Application No: FP/70/21/PL
Site Address: Kenwood Court 6 The Midway Felpham PO22 7EZ
Description of works: Erection of a car port and rearrangement of existing parking spaces. This application is in CIL Zone 4 (Zero Rated) as other development.

Thank you for your internet representation made on 19th May 2021 which has been recorded as an objection with the comments as follows:

**PROPOSED CAR PORT
PLANS AND ELEVATIONS**

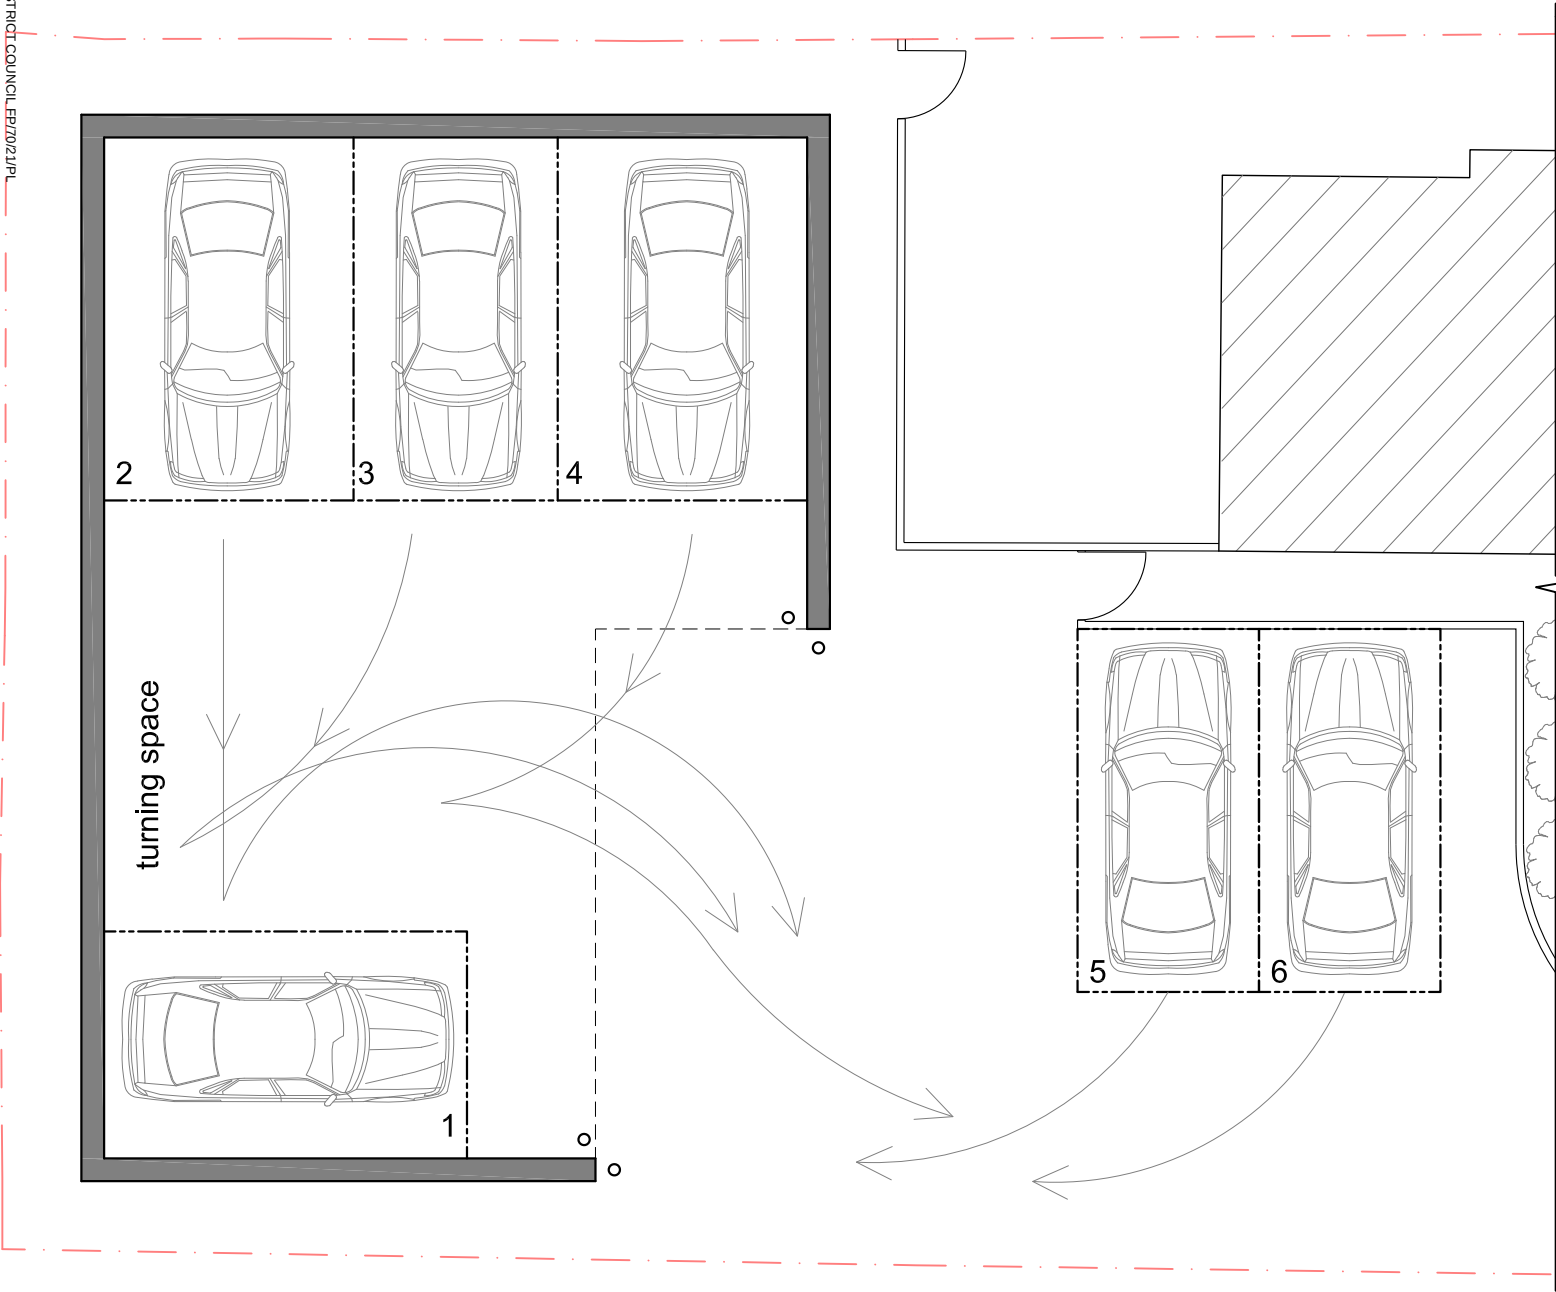
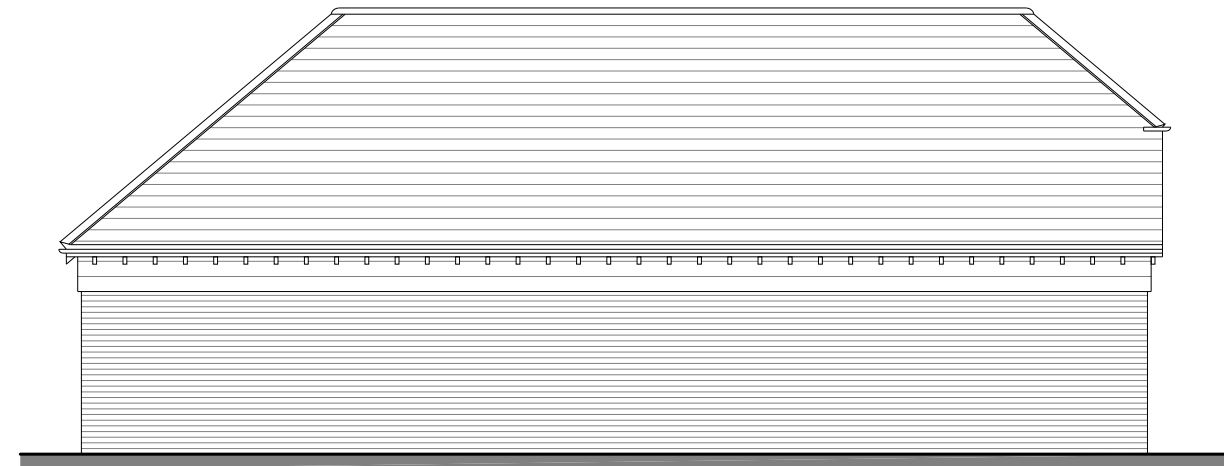
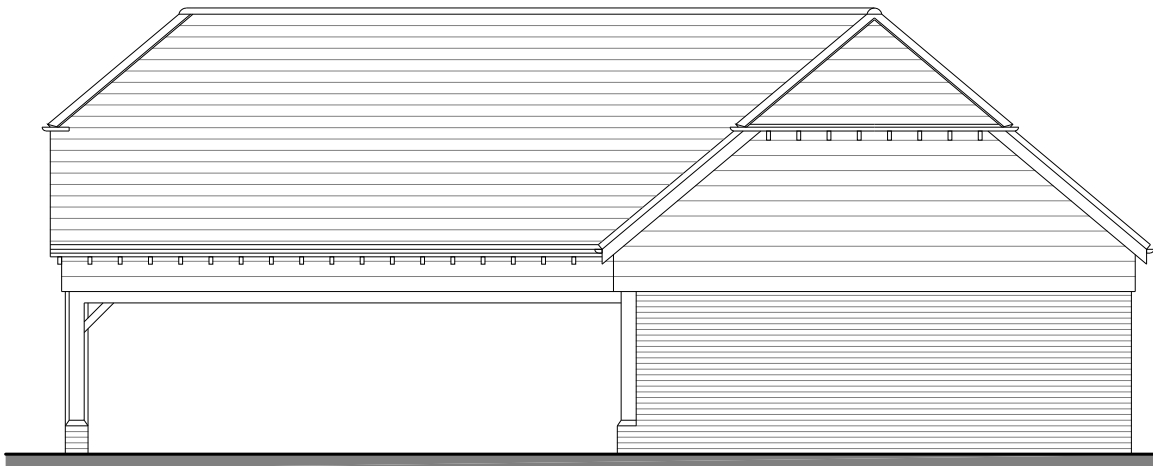
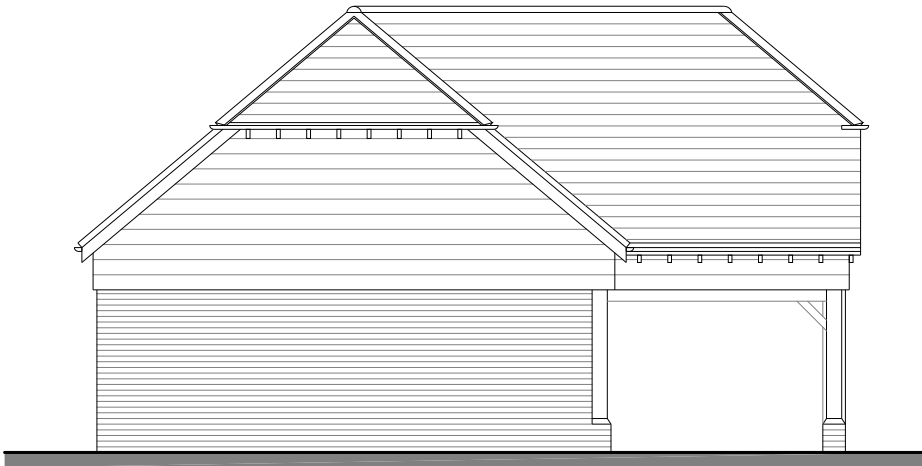
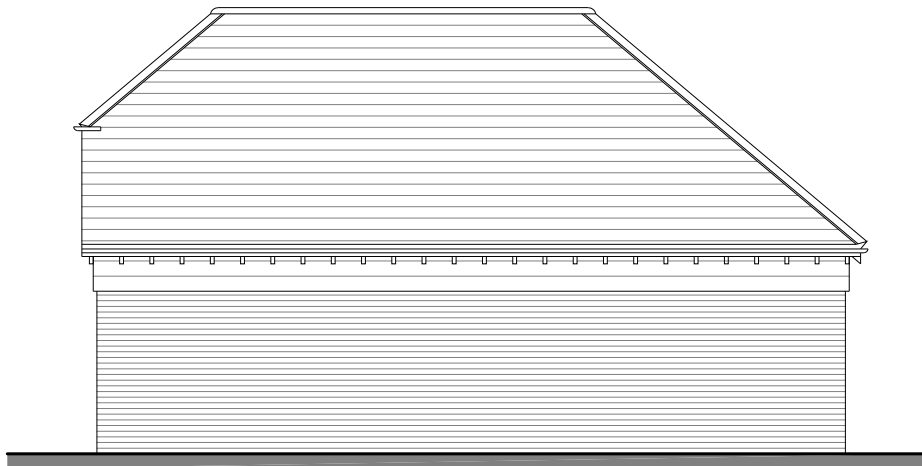
We strongly object to the proposed development to the rear of 6 The Midway. This is an enormous structure in both height and width which will significantly impact several local properties. The height will lead to loss of light and overshadowing in several directions as well as an unsightly view. There will be additional noise and disturbance resulting from its use. There is adequate parking for local needs already and this does not serve a useful purpose. It appears excessive to meet the stated purpose; in fact, the design of the structure, and materials, suggests an intention to be later converted to a dwelling. Whilst not grassed at present this is to some extent a green space, and building on it would contribute to congestion of the area. There are trees around the site that would be affected, with a consequent impact on wildlife.
